**Consultation Response from KC,
Policy**
2023/93013 Moorhouse Farm, Moorhouse Lane, Birkenshaw, BD11 2AY
Demolition of existing buildings and erection of 9 dwellings
Date Responded:
Responding Officer: Amanda Potter
Responding Ref:

Client:	Mr & Mrs Light	
Project:	Redevelopment Proposal Moorhouse Farm Moorhouse Lane, Birkenshaw, BD11 2AY	
Drawing:	Proposed Site Footprint	
Date:	Aug 2023	Scale: 1:500 @ A3
Drawing No:	2313/111	Rev: C

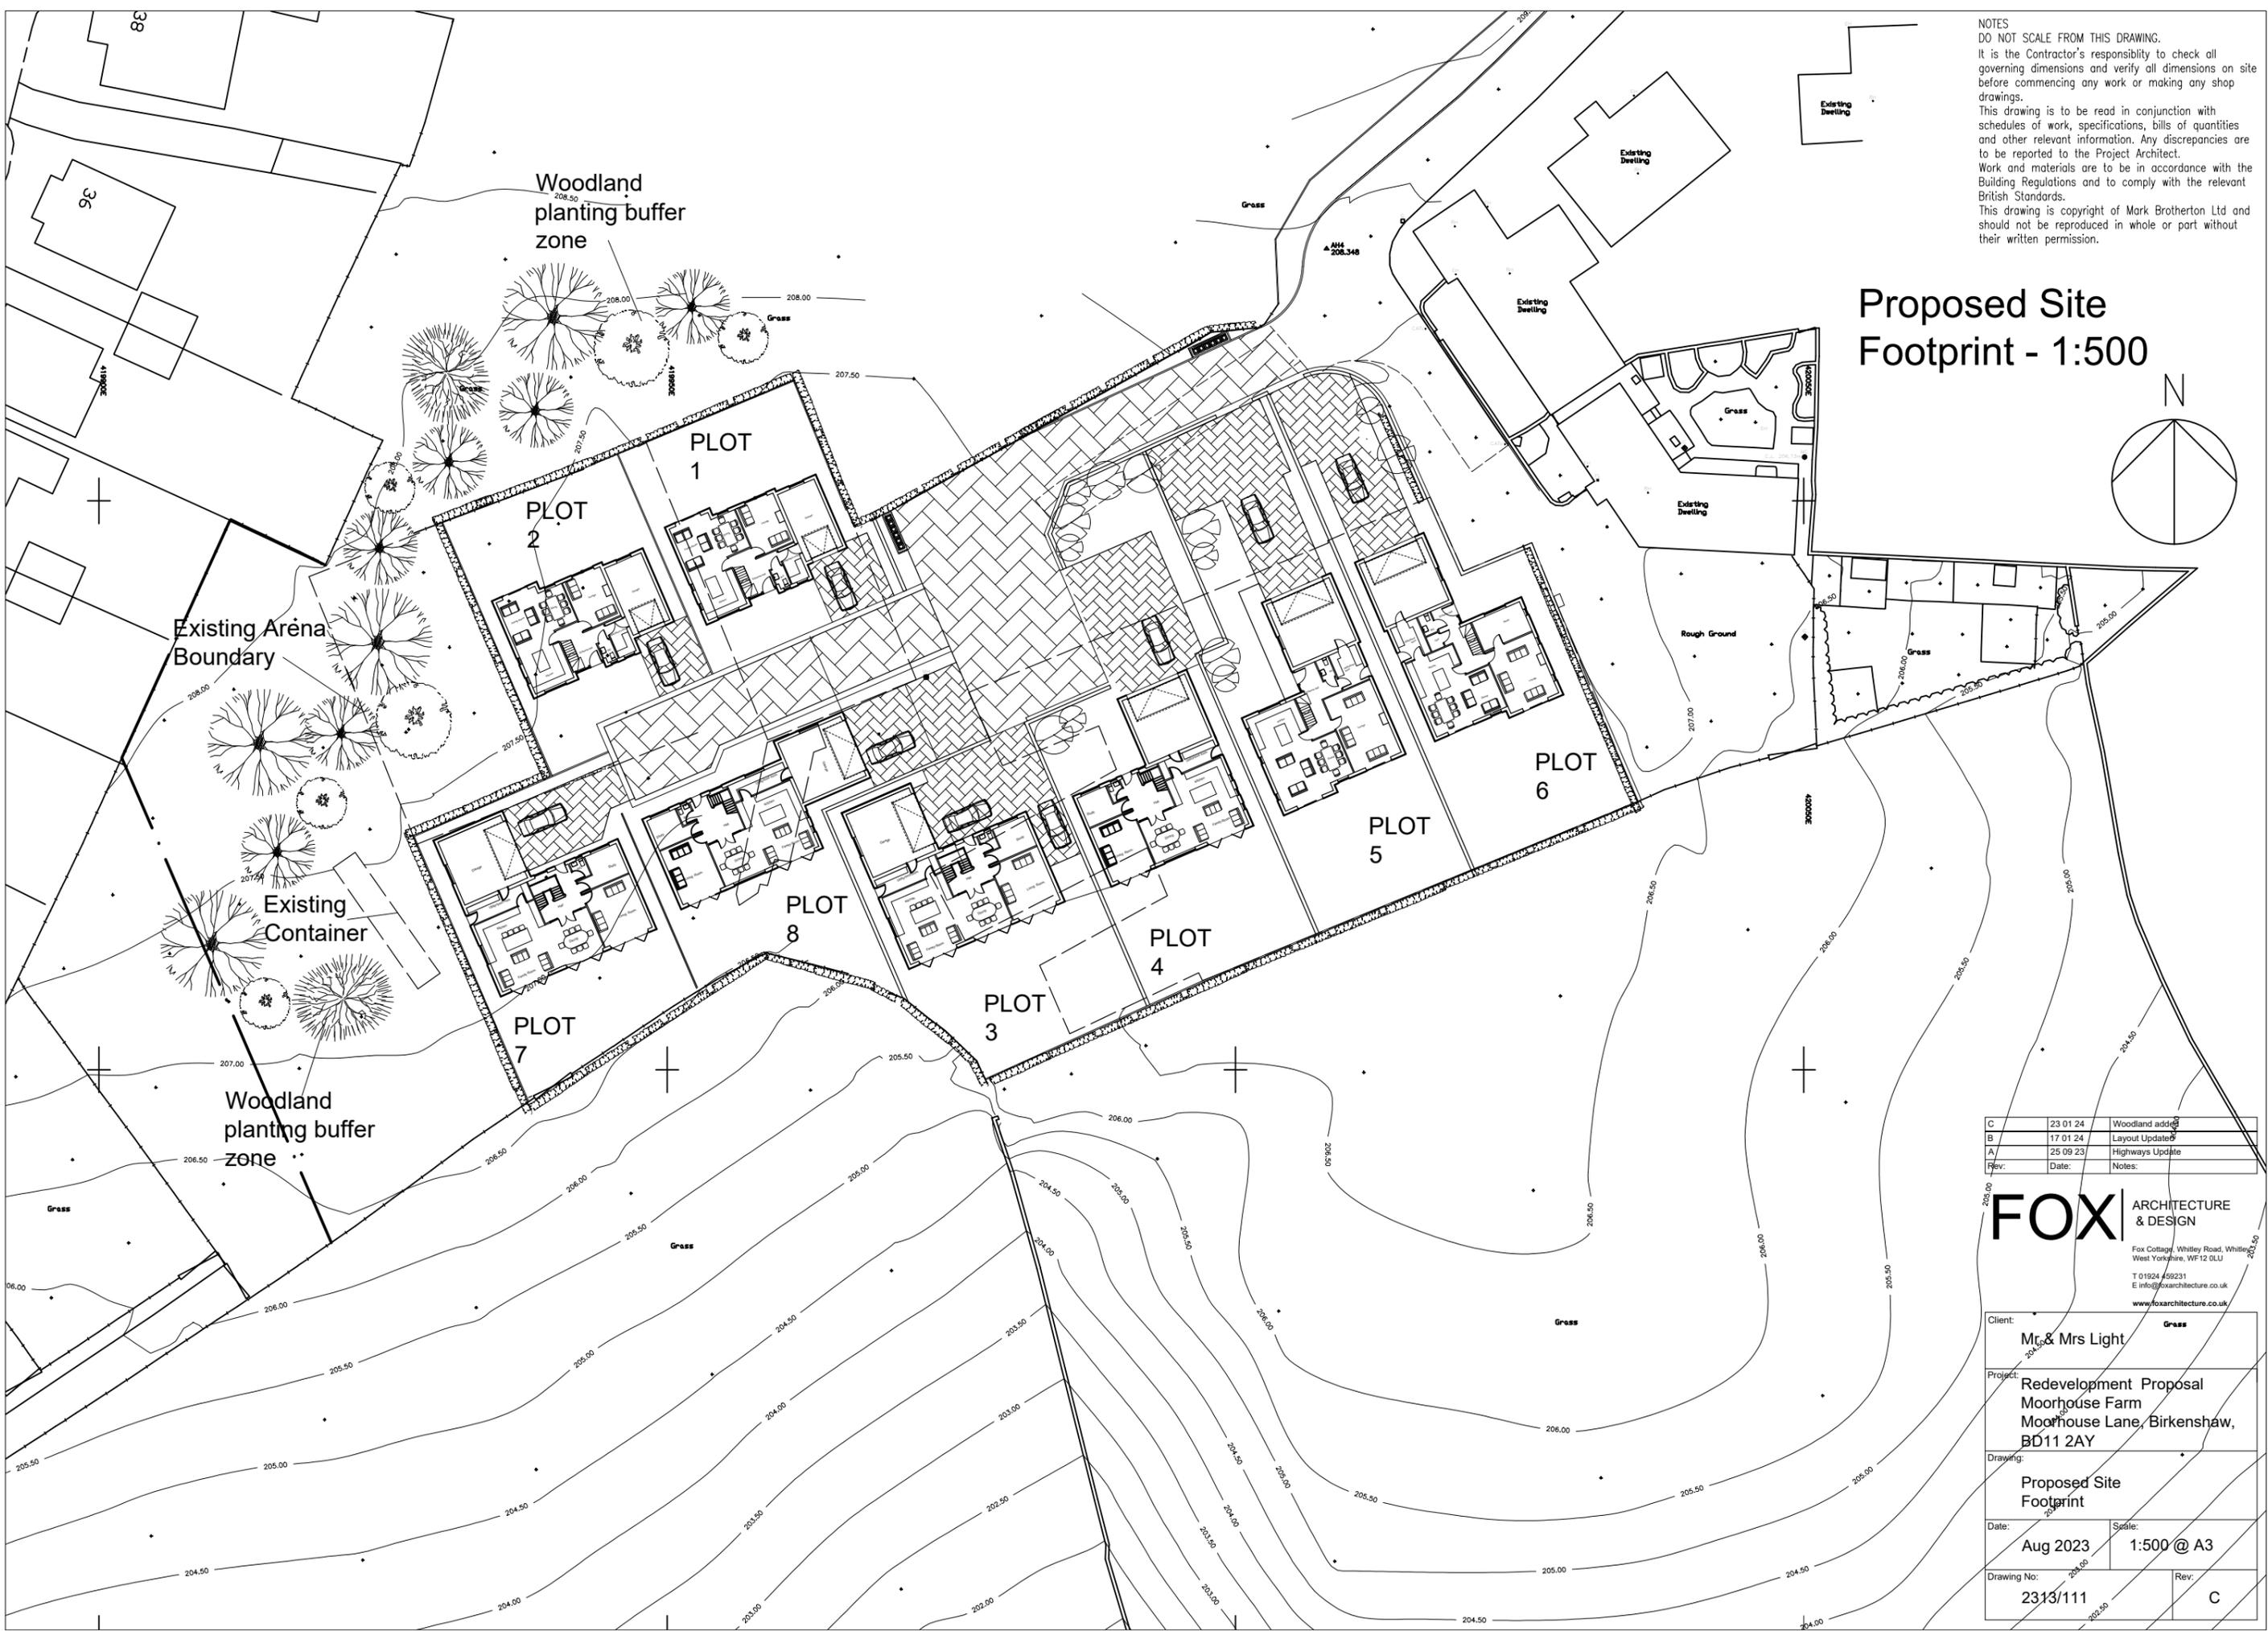
This application proposes the erection of 9 detached dwellings on a site currently used as a livery and caravan storage business. There is an existing access off Moorhouse Lane. The site comprises two large buildings located to the front/north-east of the site arranged in an 'L' shape, with an area of associated hardstanding to the rear/south-west. The site received planning permission in 2021 (application 2021/94599) for the erection of 6 dwellings. These were largely on the footprint of the existing buildings and respected the existing layout. This current scheme amends the layout and extends development further to the south/west across the area of hardstanding.

Harm is caused to the Green Belt through inappropriateness, by impact on openness and harm to the purposes of the Green Belt which is to safeguard the countryside from encroachment, in this case the encroachment of urban form. All harm carries substantial weight and in the case of the current scheme the harm caused to the Green Belt outweighs the benefit of the provision of a further three dwellings over the previously approved scheme. The harm to the Green Belt that would be caused by this

proposal is substantial and provides a clear reason to refuse the application. As such the tilted balance is not engaged. This application is not supported.
